Sheringham Shoal and Dudgeon Offshore Wind Farm Extension Projects

Cover Letter - Non-Material Change

March 2023

Non-Material Change Application

Sheringham Shoal and Dudgeon Extension Projects

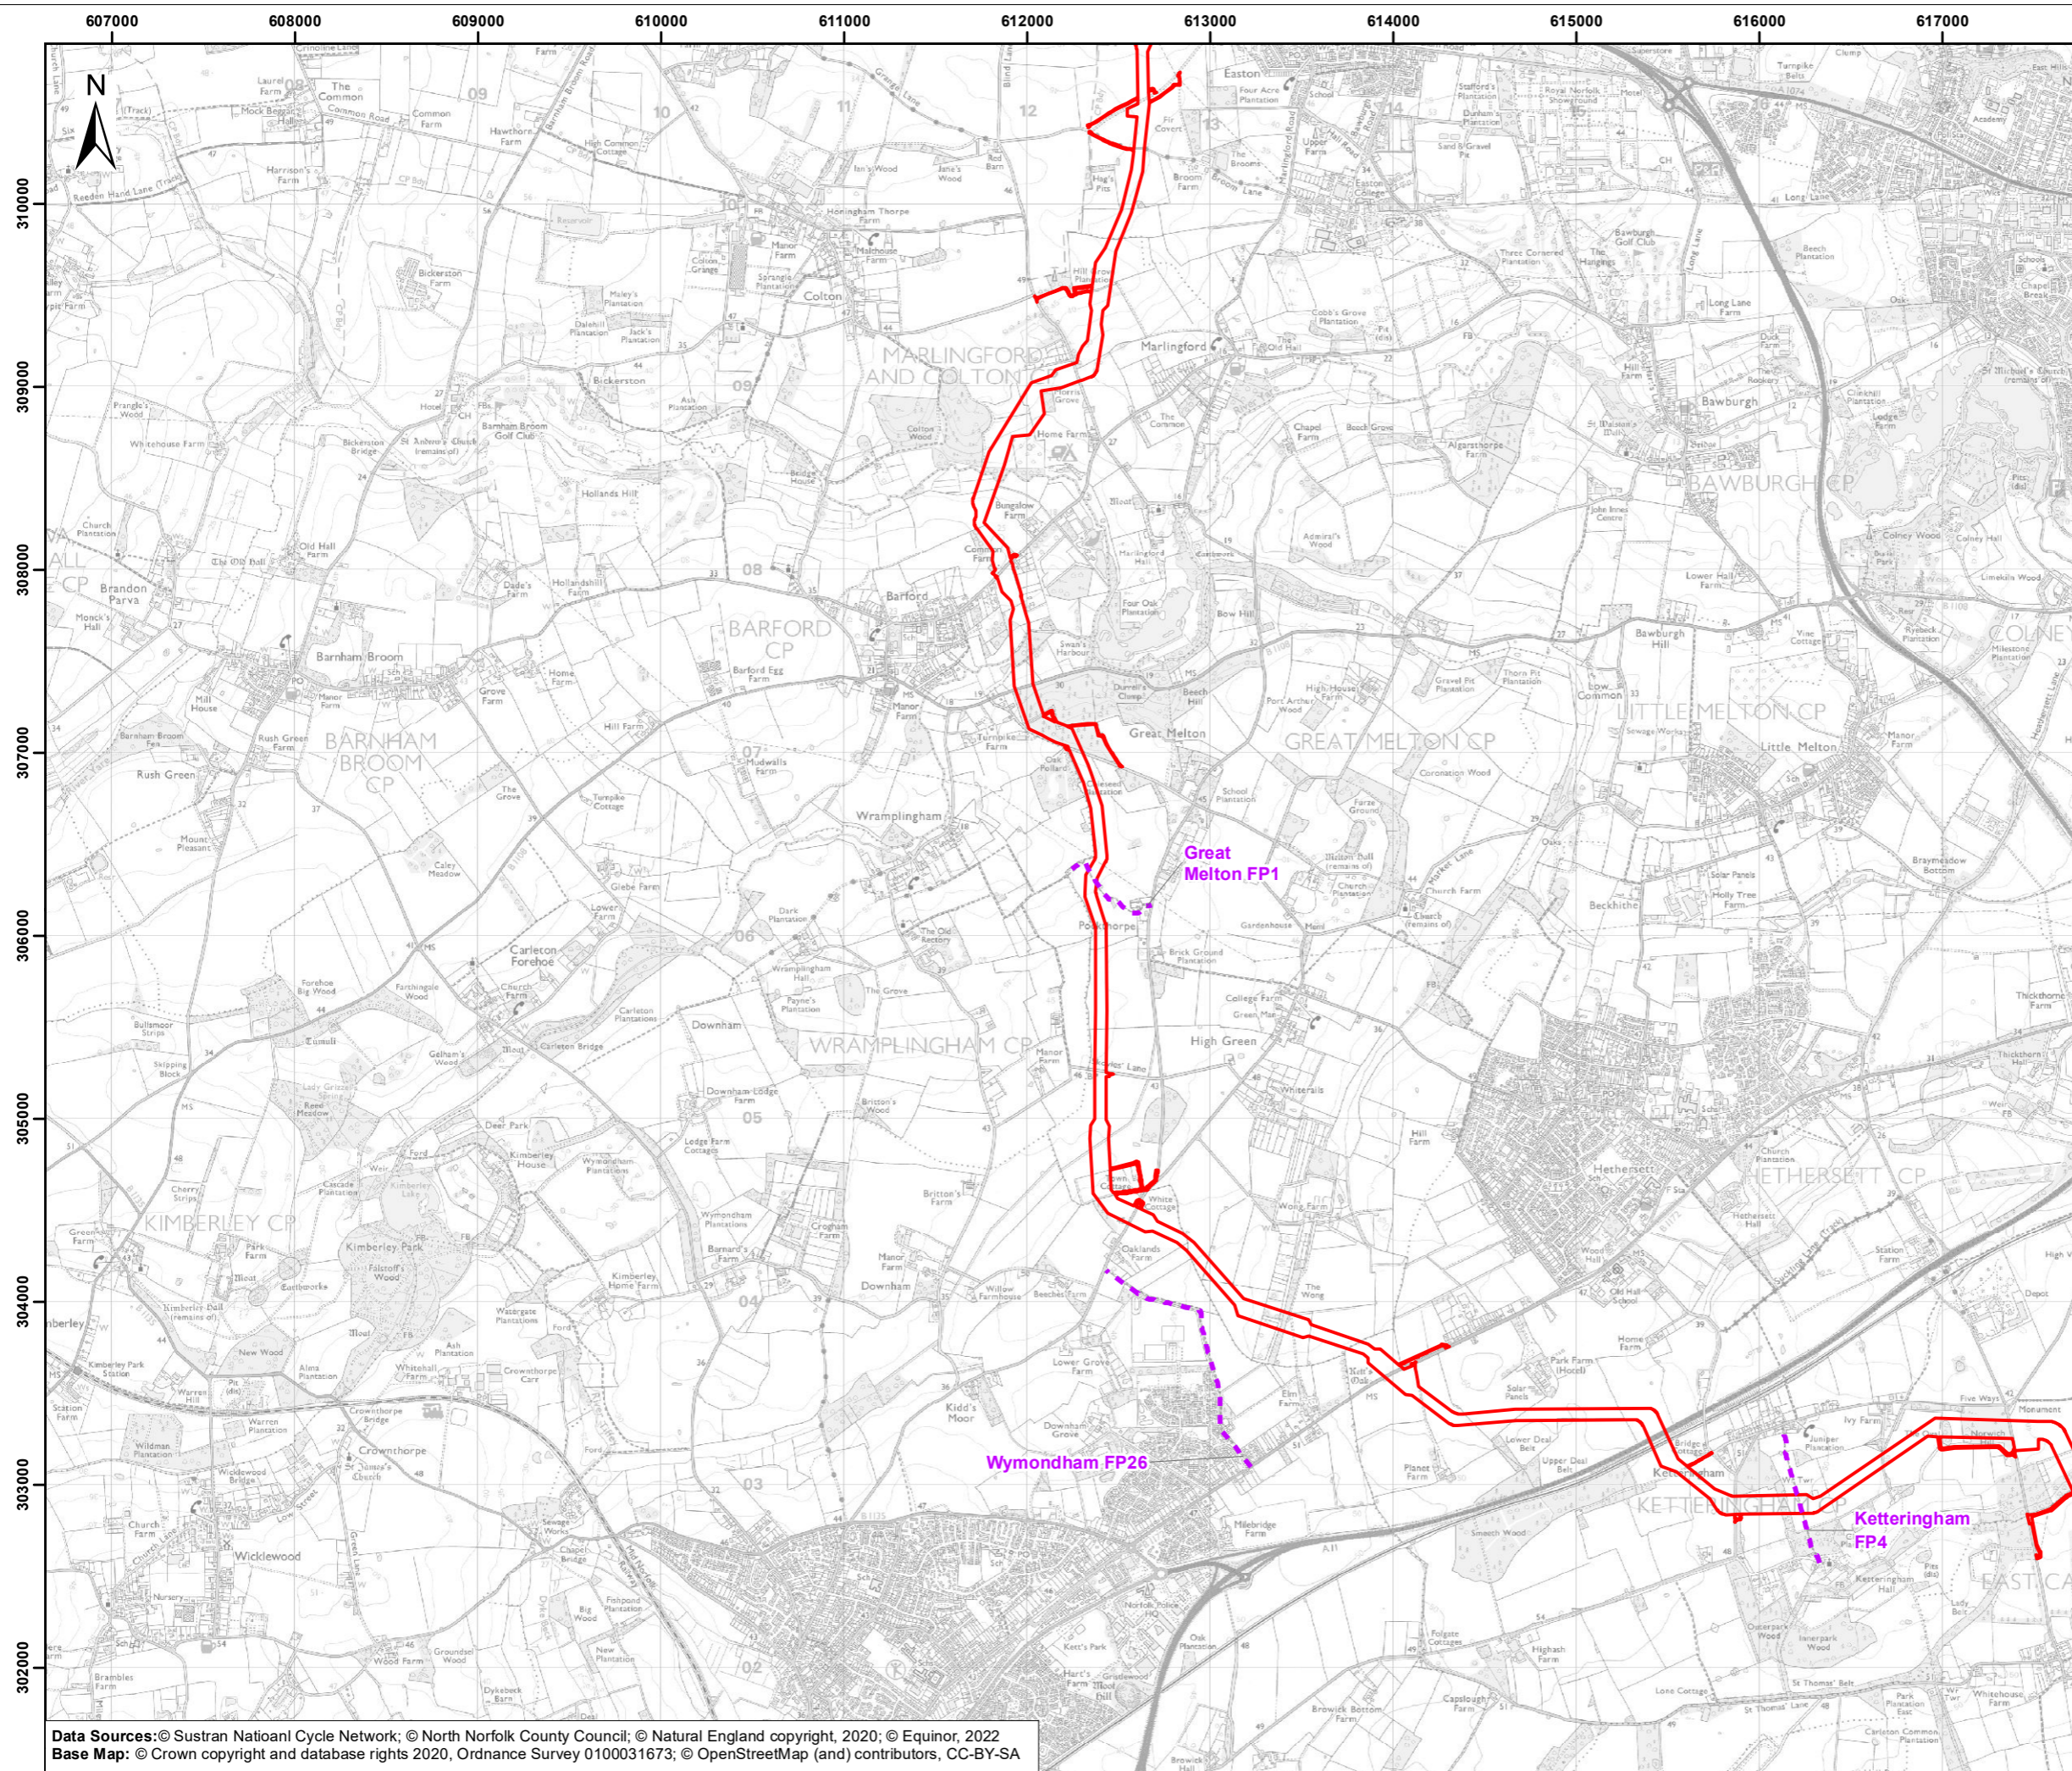
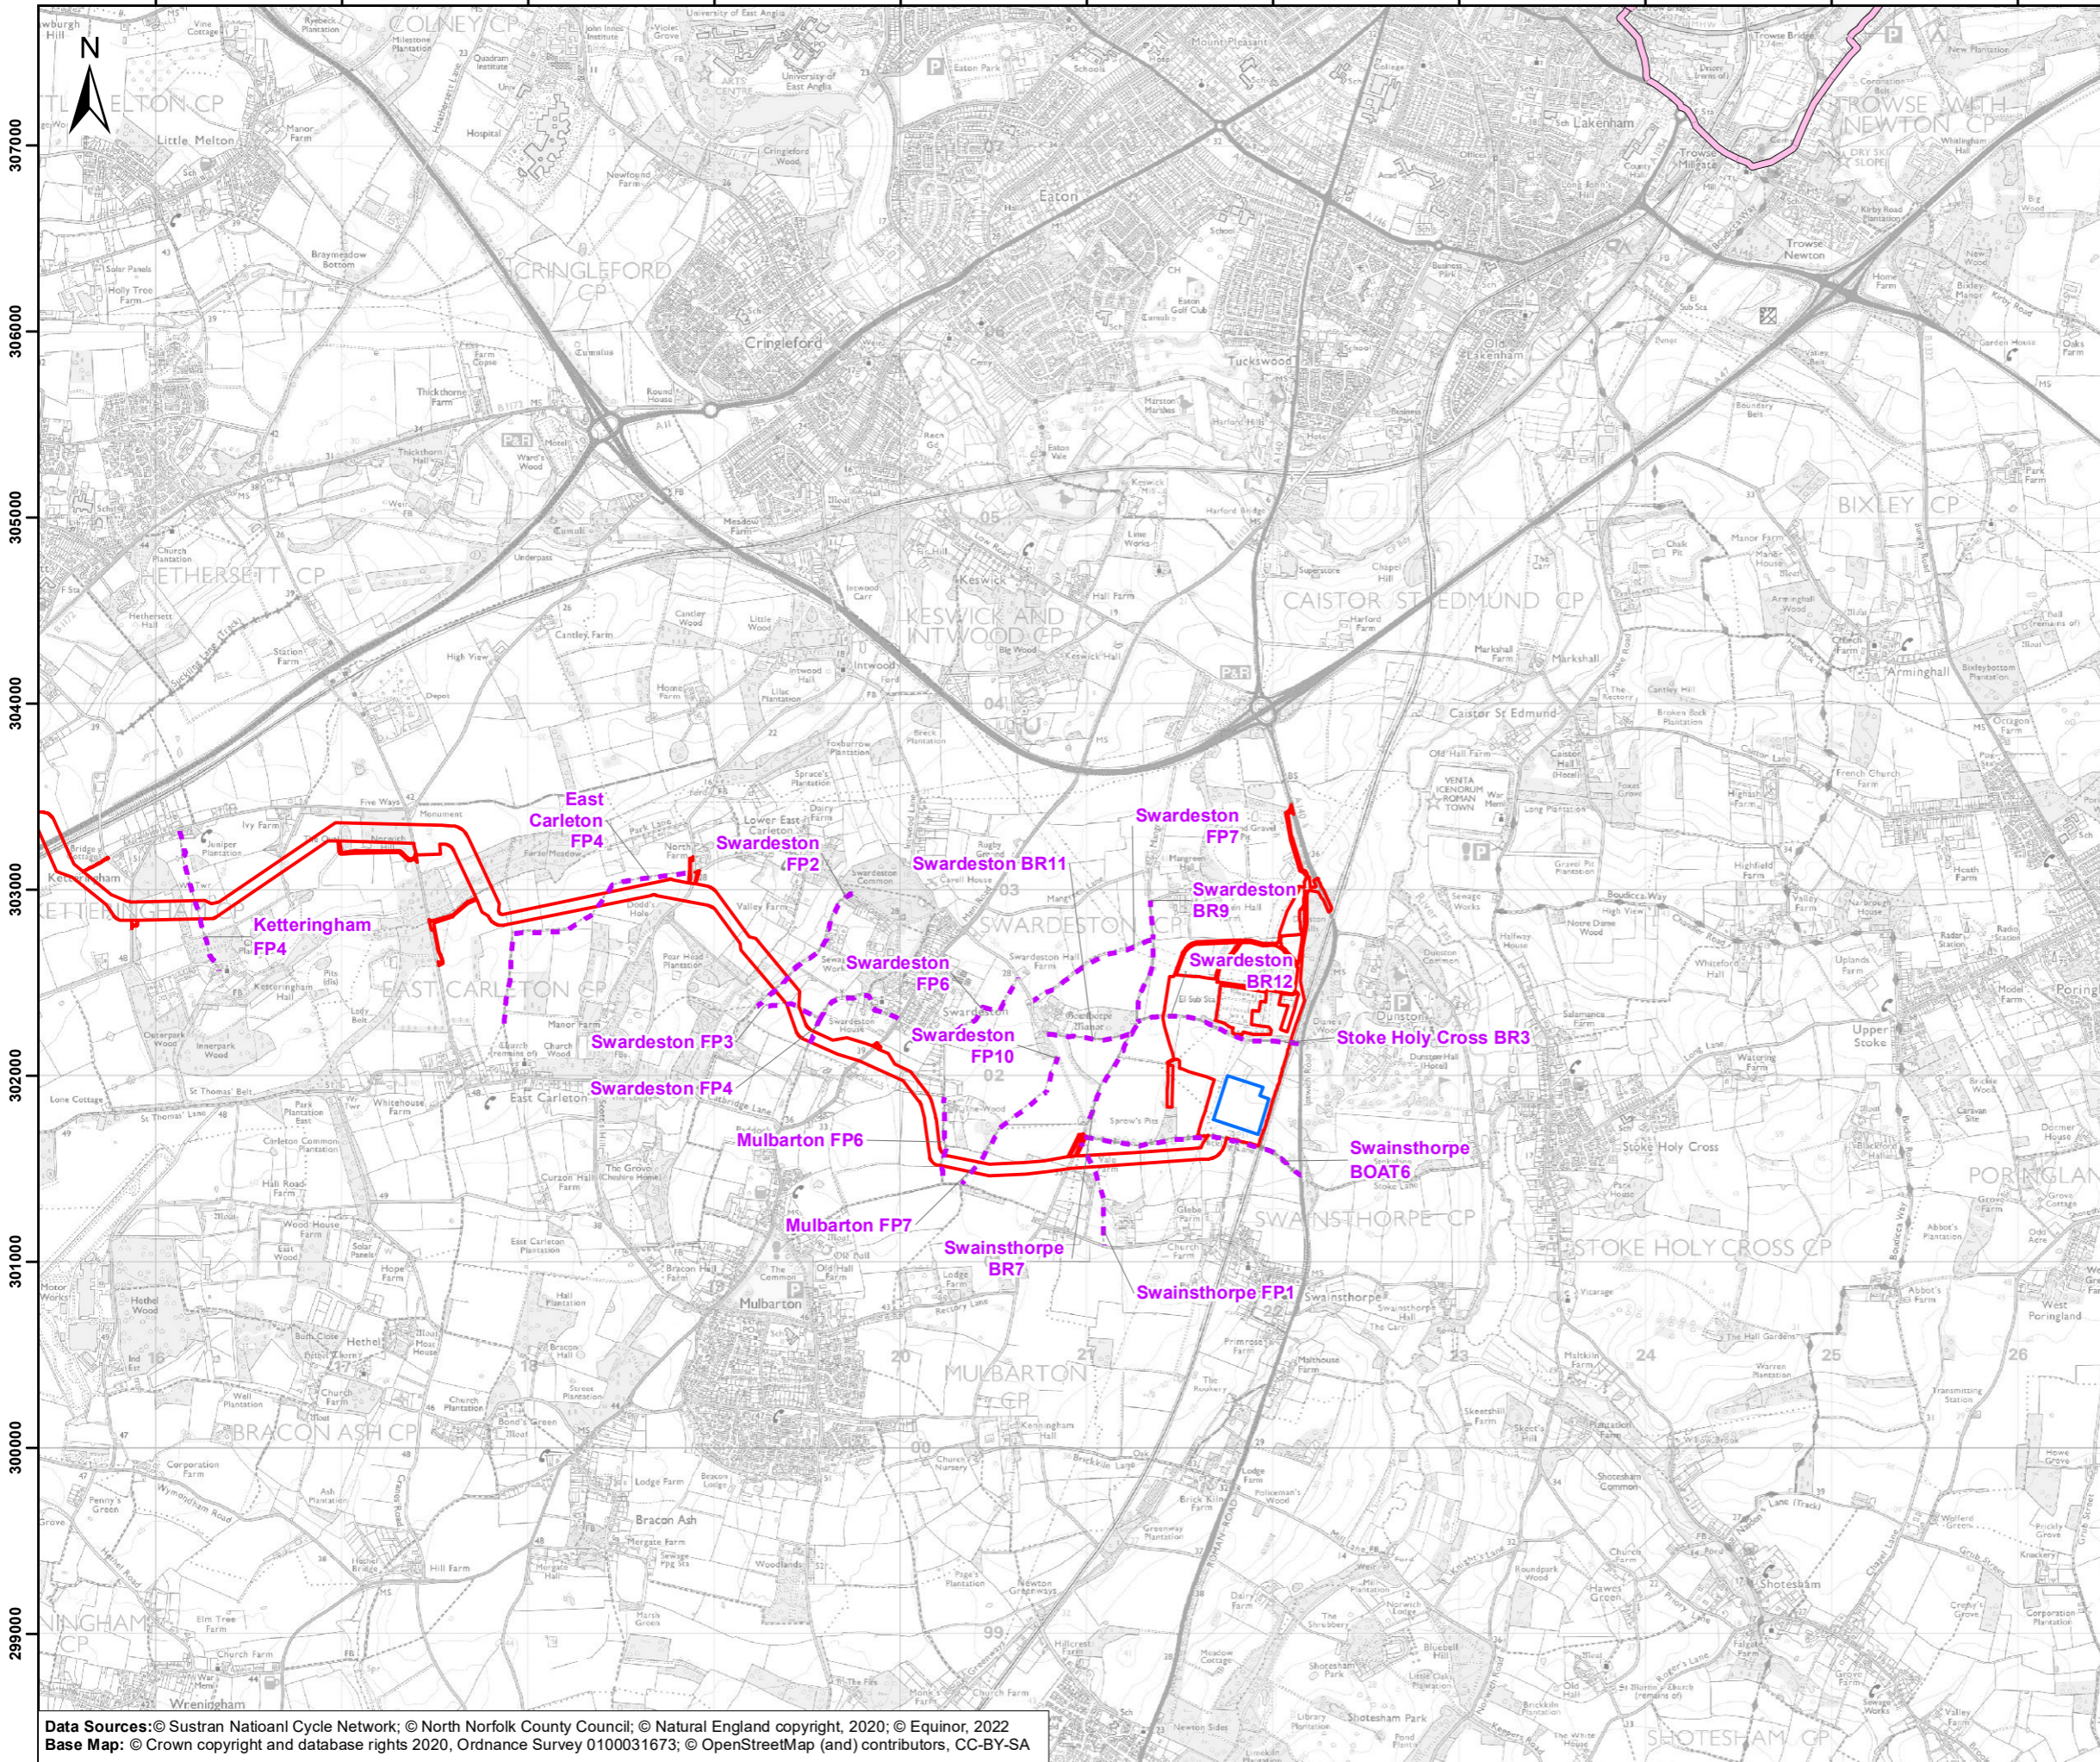
As a result of the changes to the Order Limits to remove the Anglian Water foul sewer connection, **ES Chapter 19 Land Use, Agriculture and Recreation (Revision B)** [document reference 6.1.19] and Figure 19.7 PRoW, Paths and Cycle Routes of **ES Chapter 19 Figures - Land Use, Agriculture and Recreation (Revision B)** [document reference 6.2.19] have been updated to reflect the Public Rights of Way (PRoW) which are located within the Order Limits. The number of PRoW which are intersected by the Order Limits and presented in Table 19-14 of the chapter has reduced. This reduction does not result in a change to the overall assessment and conclusion of likely significant effects presented in the chapter.

*Figure 15: Indicative Arrangement for Proposed Connection to Anglian Water Foul Sewer*

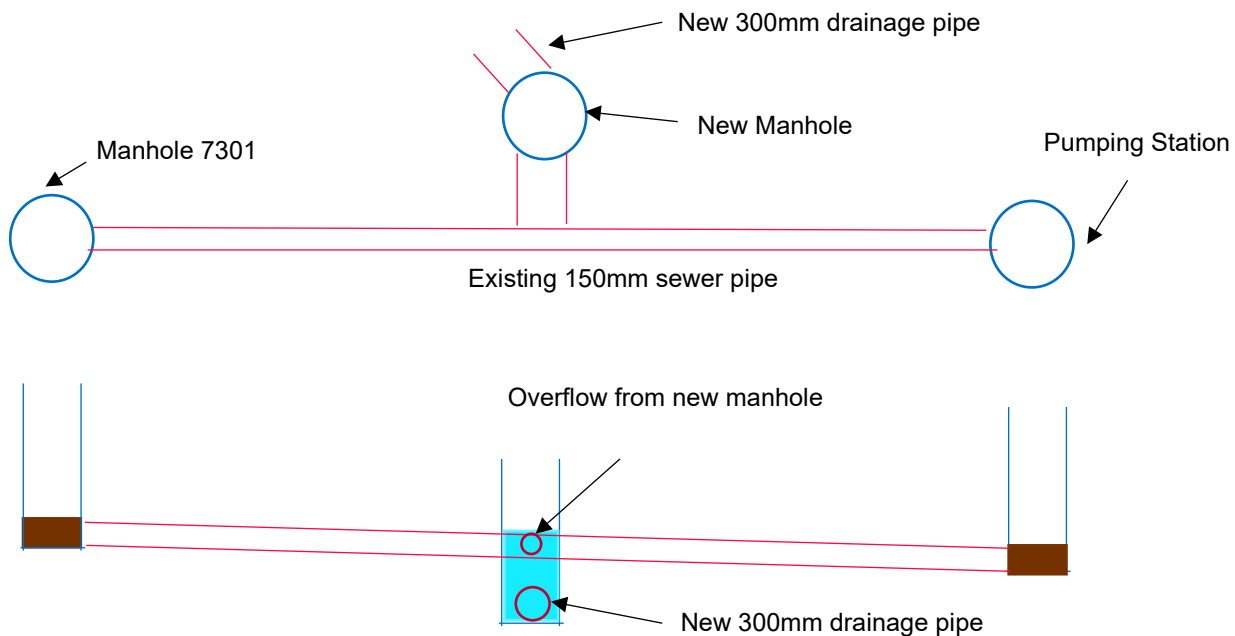
The change involves the removal of Work No 21A/B from the **draft DCO (Revision D)** [document reference 3.1] and associated changes to other documents to reflect the removal of that Work No.

The Applicant is aware that a number of other plans (which will be certified under Article 38 of the **draft DCO (Revision D)** [document reference 3.1]) will also need to be amended to reflect the removal of Work No 21A/B (related to the Anglian Water foul sewer connection). The Applicant intends to update the remainder of those plans if the non-material change request is accepted and will submit them either with the anticipated material change request or at the next available deadline (whichever is sooner).

infiltration directly into the shallow granular zone can be adopted. As such, it is proposed that a shallow infiltration solution will be taken forward as the sole surface water drainage approach at the onshore substation.
